KIRKLEES METROPOLITAN COUNCIL INVESTMENT & REGENERATION SERVICE

DELEGATED DECISION TO DETERMINE PLANNING APPLICATIONS

Reference No:	2022/62/91969/W
Site Address:	33, Foster Avenue, Crosland Moor, Huddersfield, HD4 5LN
Description:	Erection of two storey side and single and two storey rear extensions
Recommending Officer:	Ellie Worth

Officer report

Drawing Number 21-147 - P - 03 - A

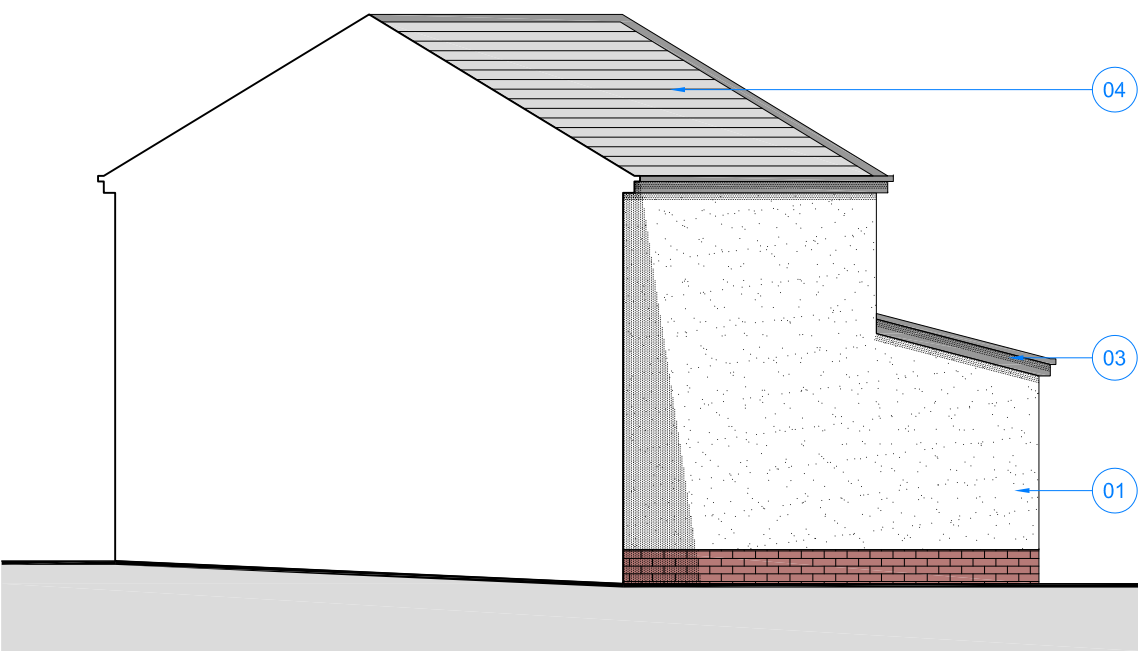
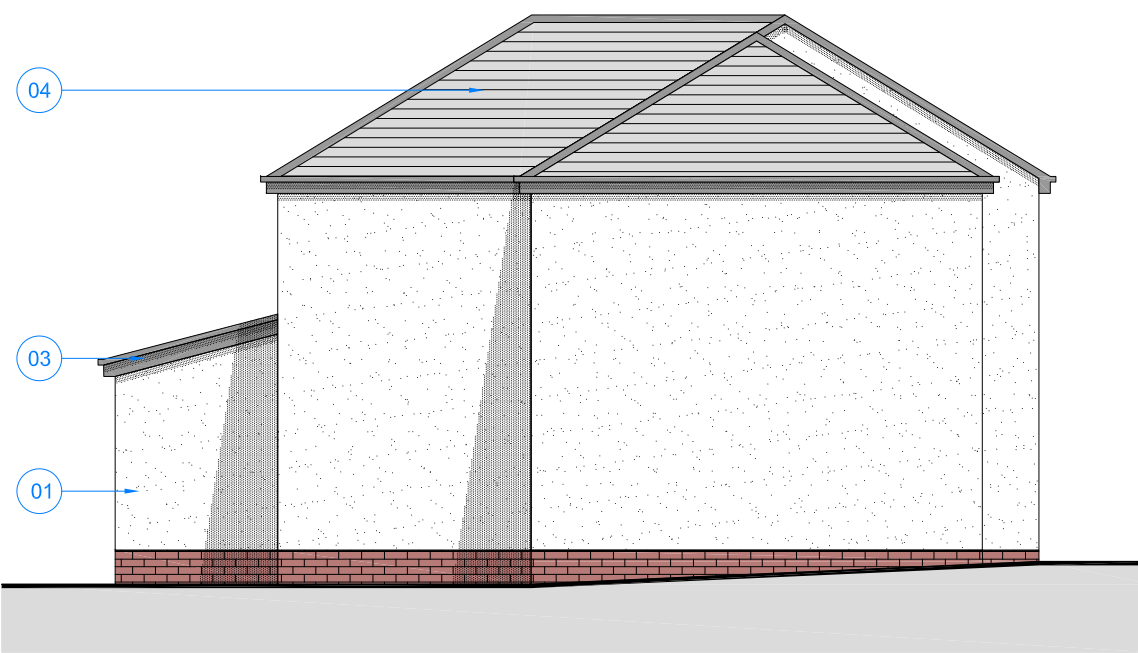
In this case, the plans show the two storey side extension to have a projection of 3.3m, which would allow a separation distance of 1m to the boundary, along with 4.3m to the nearest elevation at no. 27. The extension, given the amendments sought would also be set back from the front wall of the house by 0.5m. Therefore, the works would comply with the guidance set out within the SPD.

In terms of design, the extension would benefit from a hipped roof in order to take away some of the bulk and massing. Whilst this would have some visual impact on the application site and the neighbouring property, as it is read as a

With regards to fenestration, the plans submitted show two windows within the front elevation and two windows and bi-folds within the rear elevation. Such openings have been considered acceptable, as they would be in keeping with those that exist on the host property.

PROPOSED STREET SCENE
Scale 1:100@A1

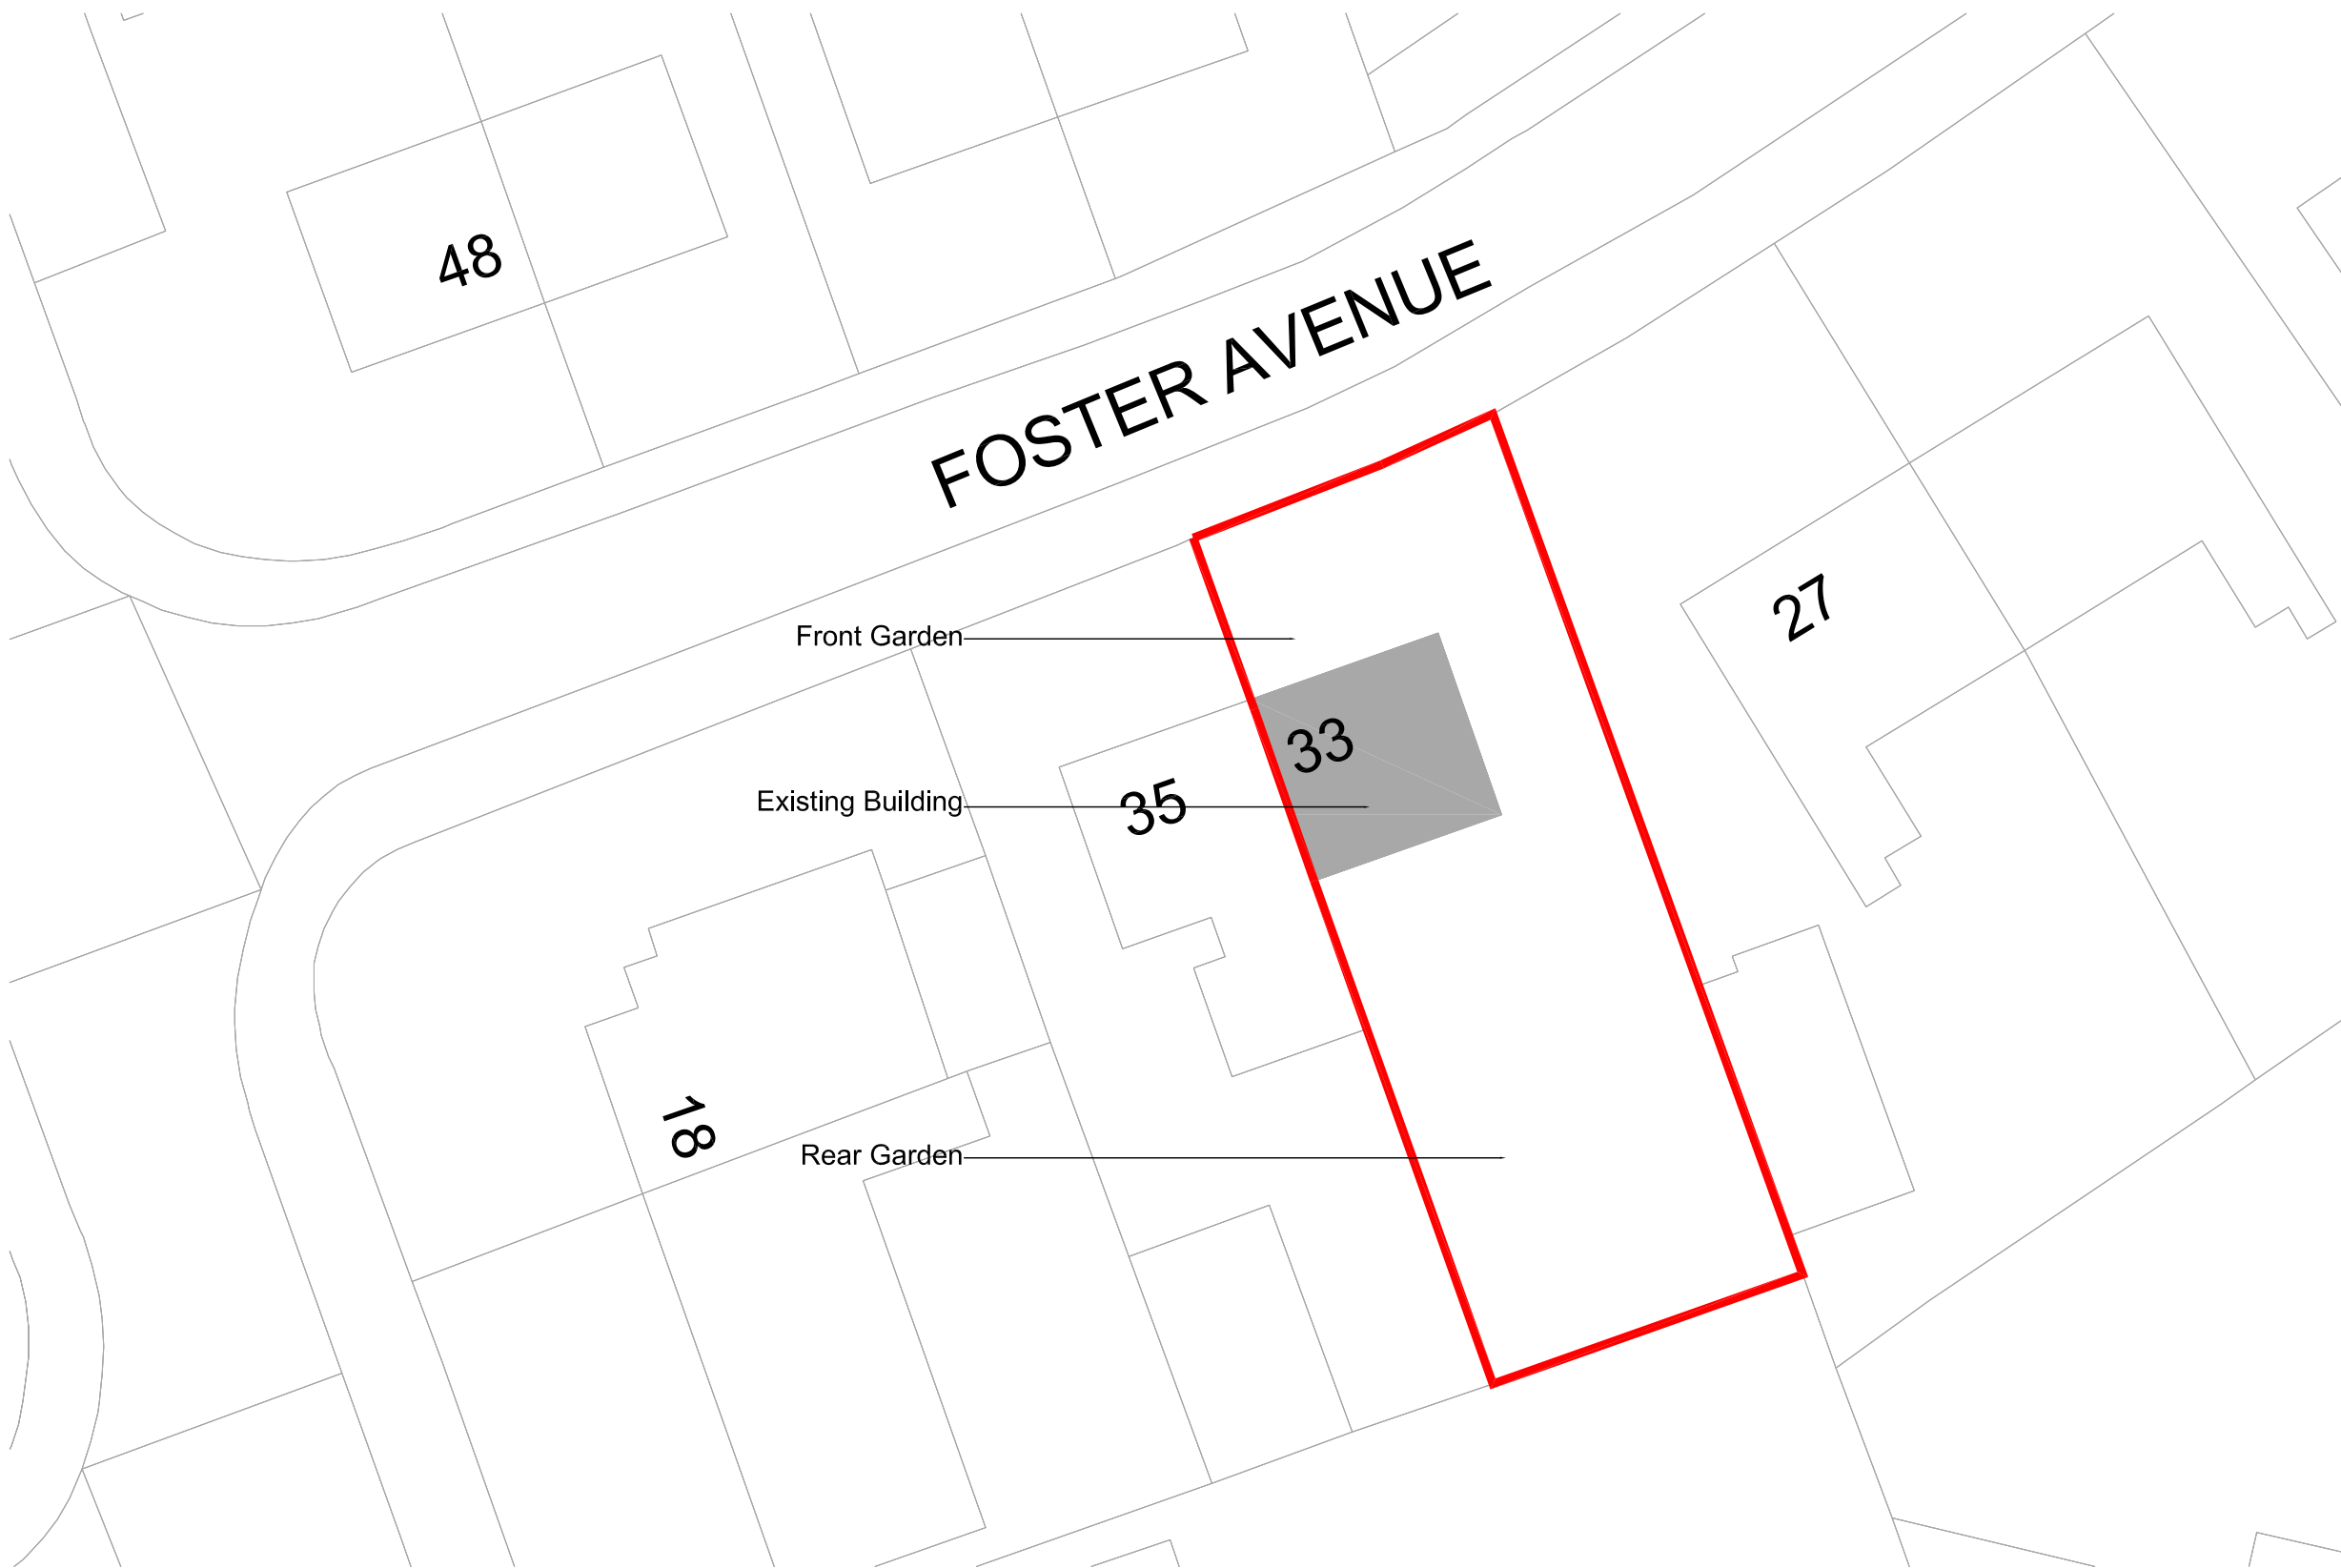
pair of semi-detached dwellings, officers have noted that there are a mixture of hip and gable roofs along Foster Avenue. Therefore, the extension is not considered to appear incongruous within the street scene.

PROPOSED SITE PLAN
Scale 1:100@A1

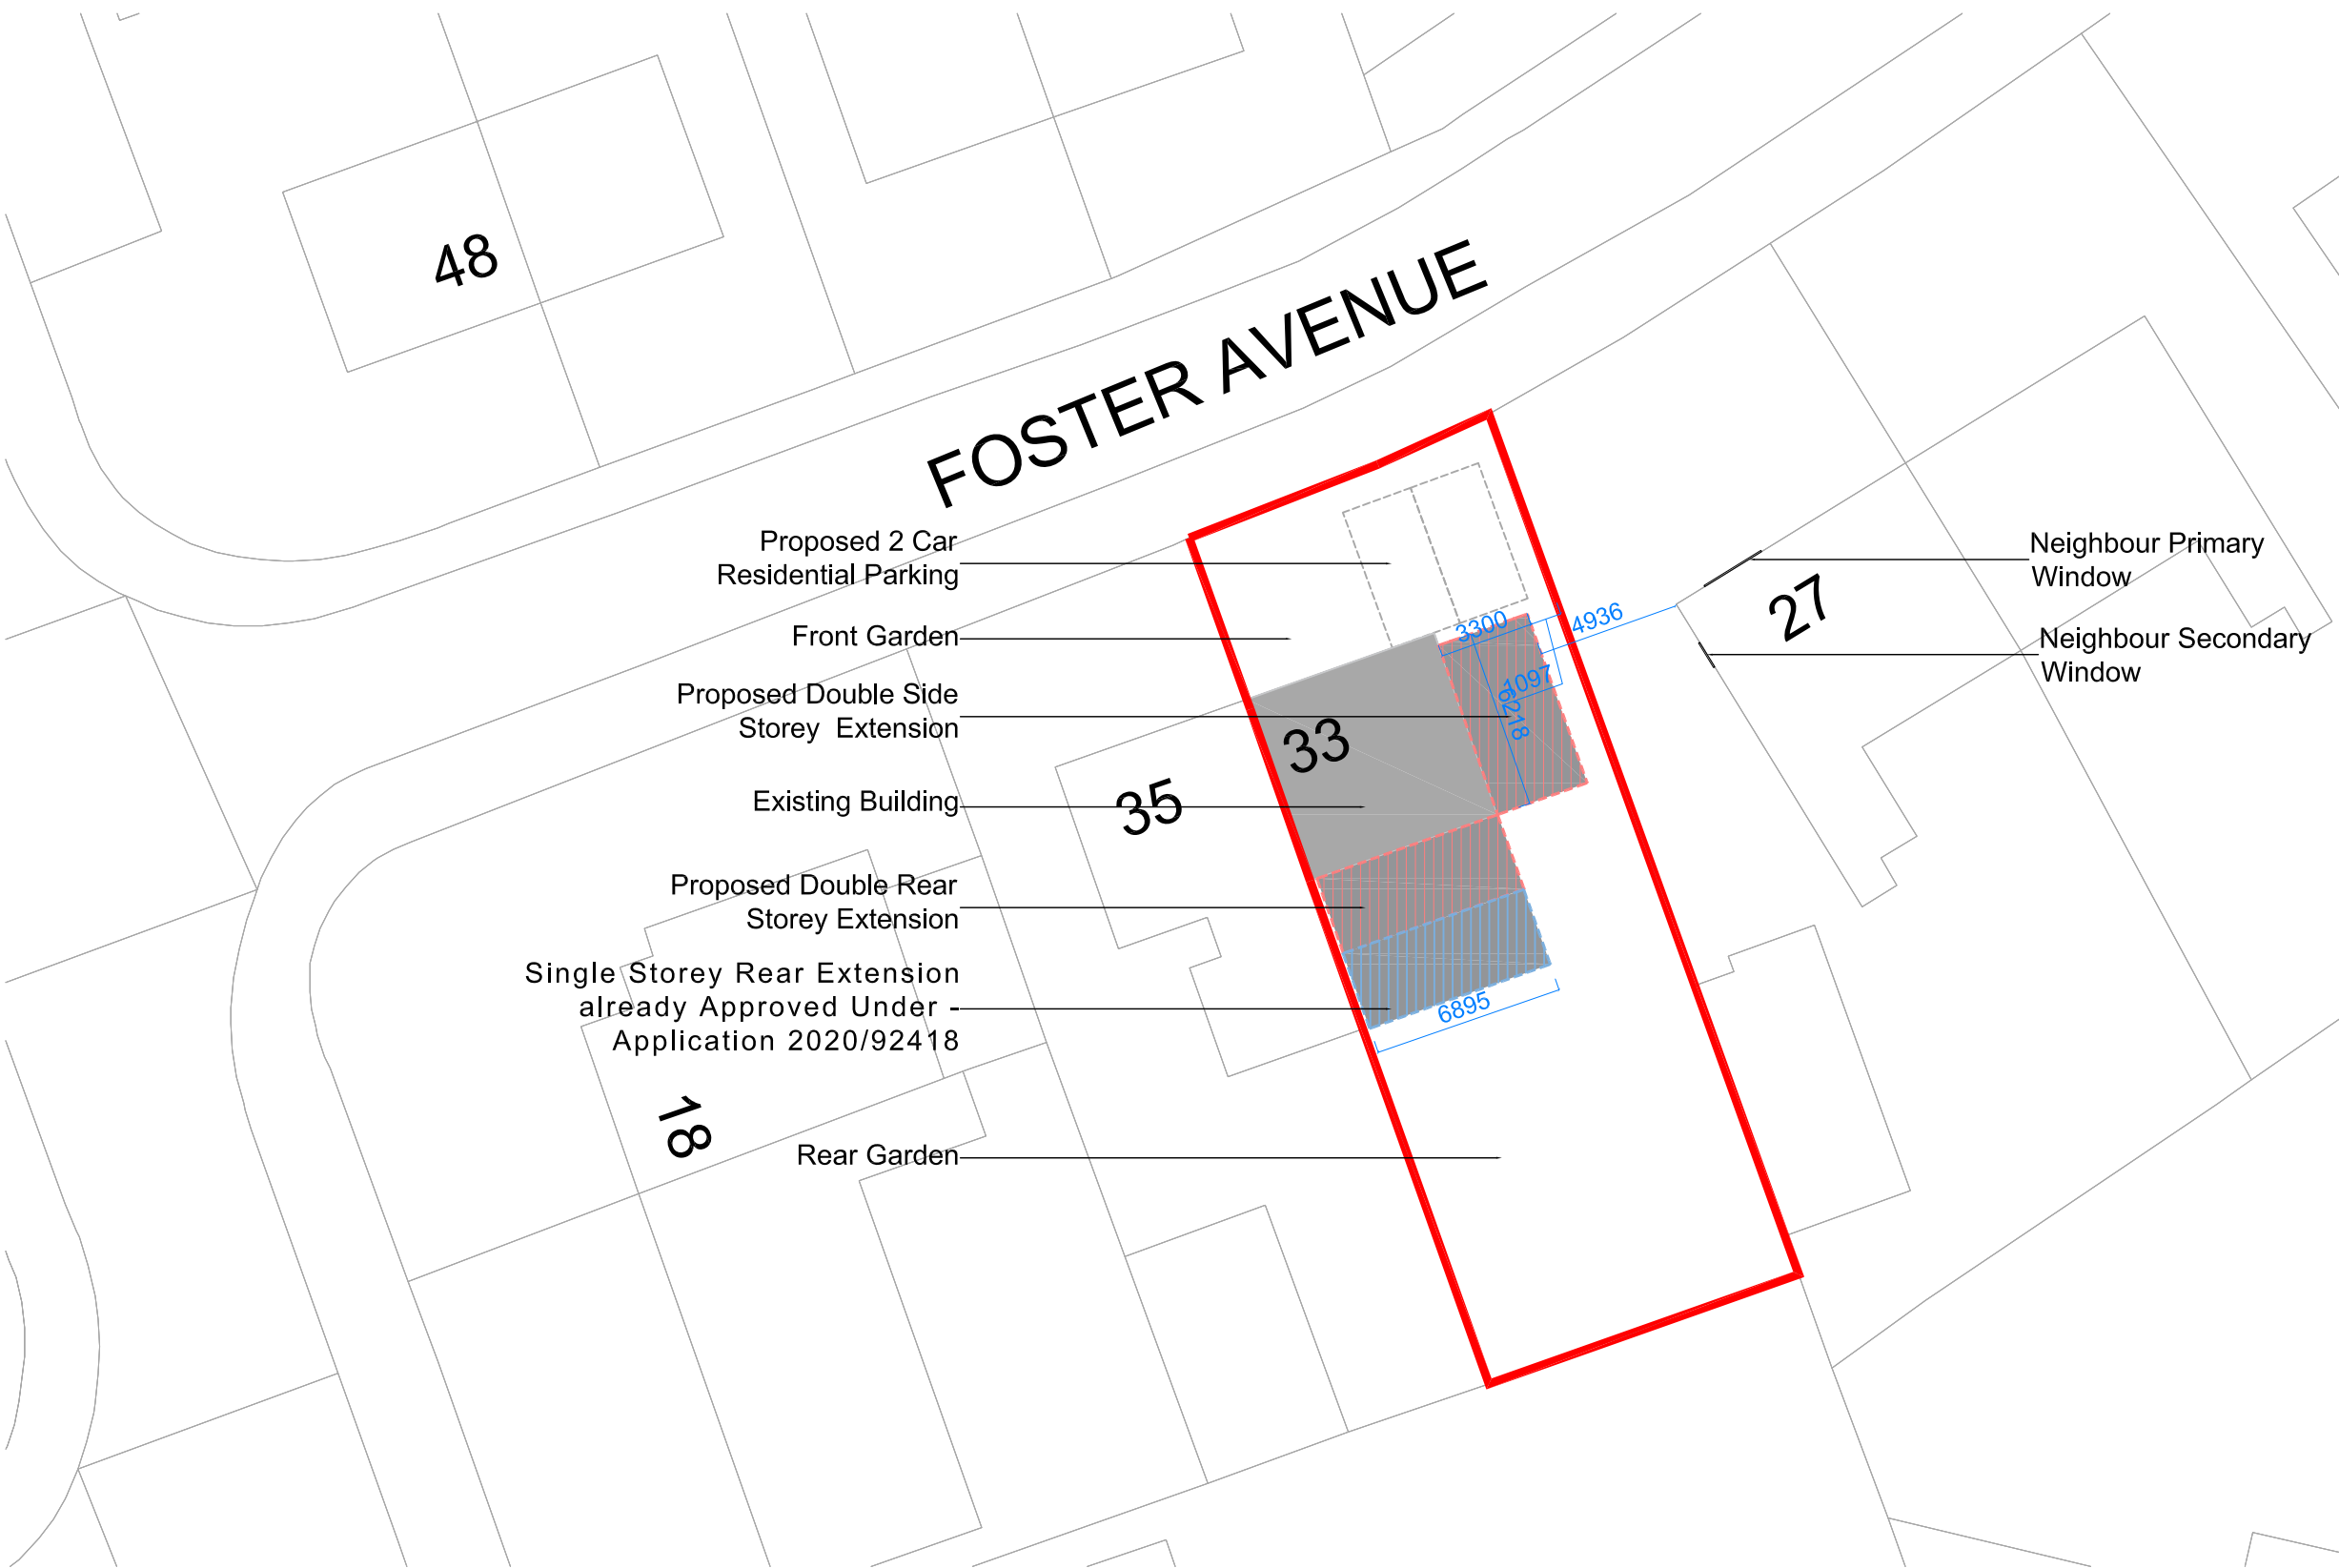
The application proposes to create a new access for on site parking which would be done under a S184 agreement with the Council's Highways Department. The officer has also requested for site lines to be provided to show visibility, however, given that the works do not require formal planning permission and instead are covered under the Highways agreement, it has not been considered fair or necessary to request this additional information.

Furthermore, there is no turning space associated with the parking and this would require vehicles to reverse to park. There are a number of dwellings that already have this type of off street parking so the principle of this has already been established and is not considered to be detrimental to highway safety.

The proposal however, would increase the number of bedrooms from 3 to 5 and therefore in accordance with local guidance would require 3 off street parking spaces. In this instance Dwg no. 21-147-P-04-C shows two. This is an increase as currently there is no off street parking associated with the dwelling and therefore on balance, due to such increase no concern is raised in this regard.

It is also important to note that the front garden is approximately 6m x 9m and could therefore accommodate 3 off street vehicle parking spaces in the future. However it is considered the scheme as proposed, with retention of soft landscaping to the front, has a good balance of landscaping and parking such that the visual impact is not that of a stark, parking dominated, front amenity space.

5. Before the extensions are first brought into use, the new driveway as indicated on the hereby approved site plan (dwg no. 21-147-P-04-C), shall be laid out with a hardened and drained surface in accordance with the Communities and Local Government; and Environment Agency's 'Guidance on the permeable surfacing of front gardens (parking areas)' published 13th May 2009 (ISBN 9781409804864) as amended or any successor guidance; Notwithstanding the provisions of the Town and Country Planning (General Permitted Development) (England) Order 2015 as amended (or any Order revoking or re-enacting that Order) this shall be so retained, free of obstructions and available for parking.
